## ONLINE COMMENT ON PLANNING APPLICATION 23/11296

Location Land adj to 20 OAKLEY CLOSE, HOLBURY,  
FAWLEY SO45 2PJ

Objection received from Mr Daniel Thomason  
17 Ruxley Close  
Holbury  
Southampton  
SO45 2PH

Drawing Title: **Tree Protection Plan**
 Drawing No: RNapc/525/TPP/3
 Date: 20th November 2023
 Scale/Sheet: 1:200 - A2
 Client: Mr M Readhead
 Site/Project: Rear of 20 Oakley Close, Holborn Southampton SO45 5PJ
 Drawn By: CS Checked By: RN

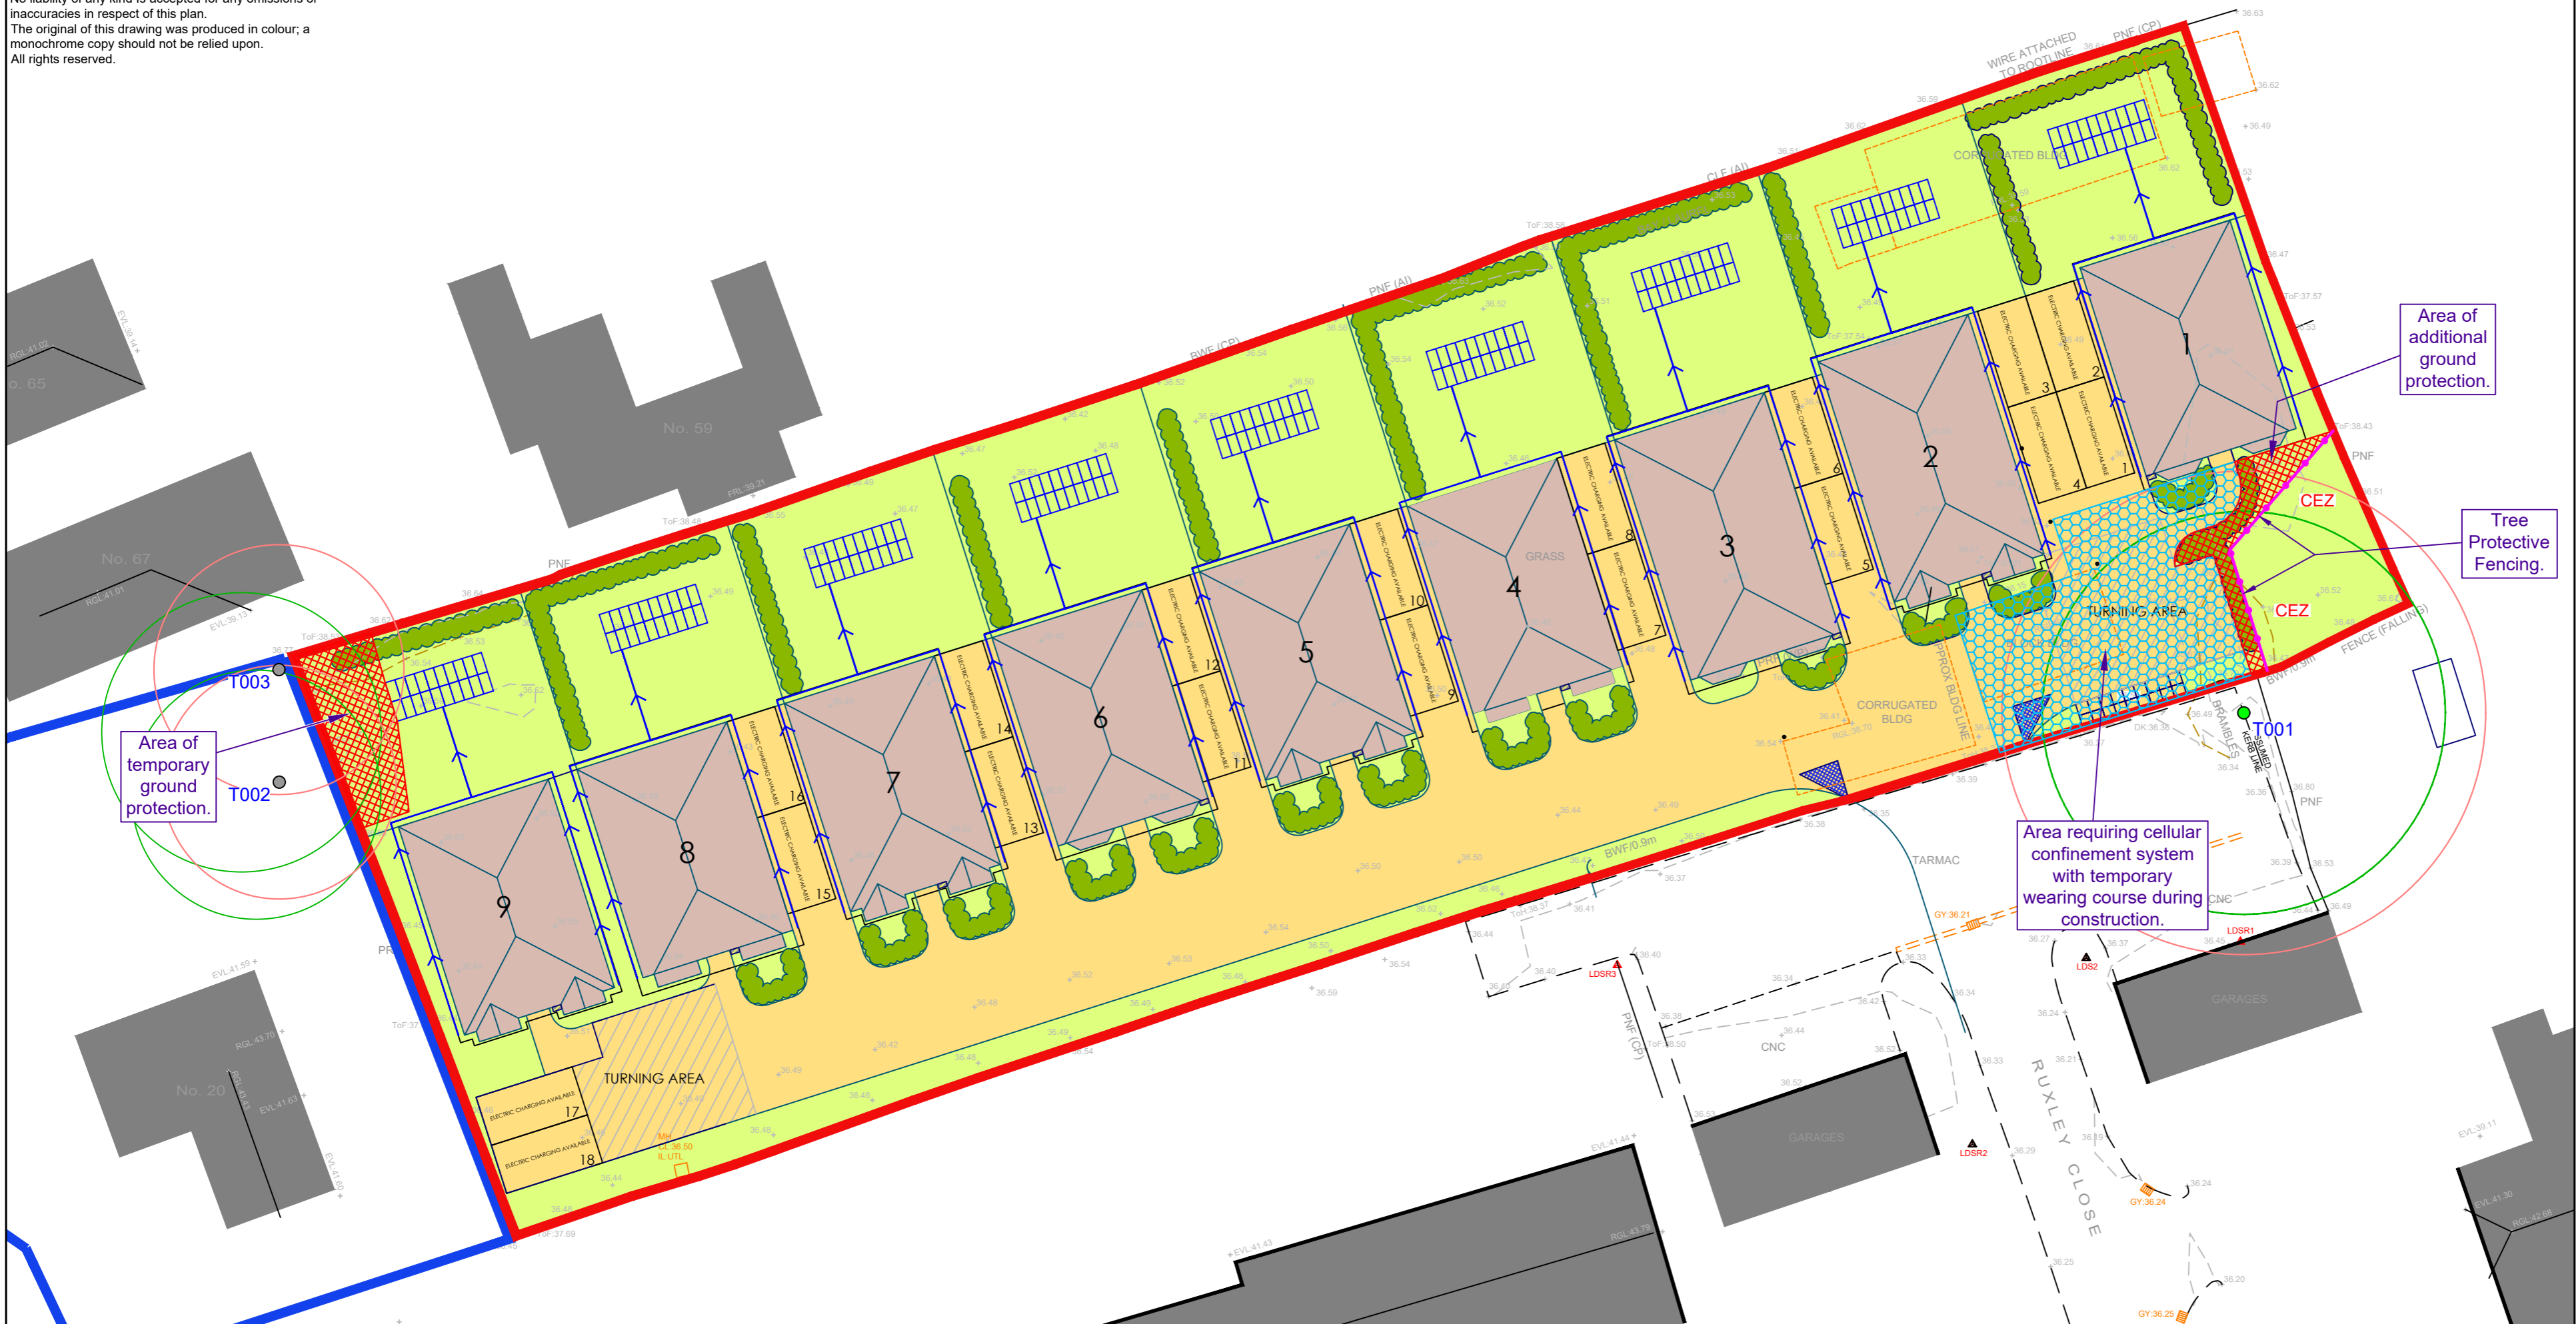
There is a wide variety of wildlife including foxes, badgers, and squirrels that currently live in the surrounding trees and hedgerows to the site, the proposed development will cause significant disturbance to them and prevent further species from residing in the area in the future.
